SECTION 4.55(1A) MODIFICATION APPLICATION – SSD 6965 BUILDING R4B, ONE SYDNEY HARBOUR, BARANGAROO SOUTH

This modification application has been prepared by Ethos Urban on behalf of Lendlease (Millers Point) Pty Ltd (Lendlease), pursuant to section 4.55(1A) of the *Environmental Planning and Assessment Act 1979* (EP&A Act) to modify Development Consent SSD 6965 relating to Residential Building R4B, One Sydney Harbour, Barangaroo South (the site).

The proposed modification application to SSD 6965 seeks approval for the introduction of a new building signage zone to the southern frontage of Building R4B, located on the basement entry ramp (in ground).

LEVEL	RL
Ground Floor	3.500

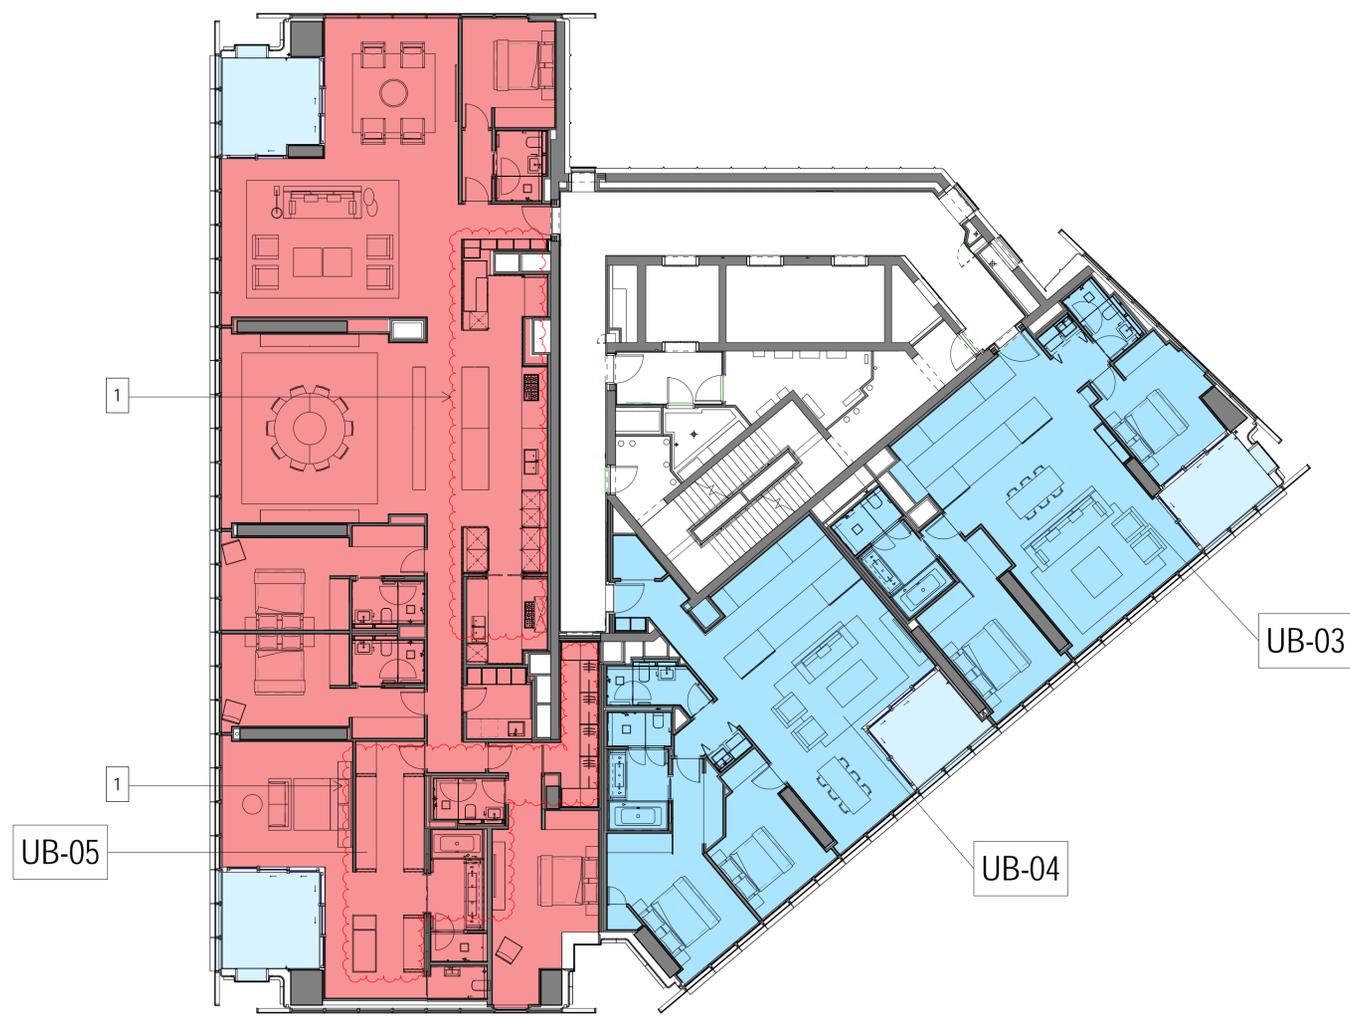
This modification seeks to introduce a new building identification signage zone to the southern frontage of Building R4B, located on the basement entry ramp (in ground).

A new building identification signage zone is proposed to be located within the ground at the basement parking entrance ramp on the southern frontage of Building R4B. This signage is proposed to comprise of recessed metal lettering within the stone paving of the driveway comprising the words 'One Sydney Harbour', and will assist in wayfinding for visitors and residents of the three buildings.
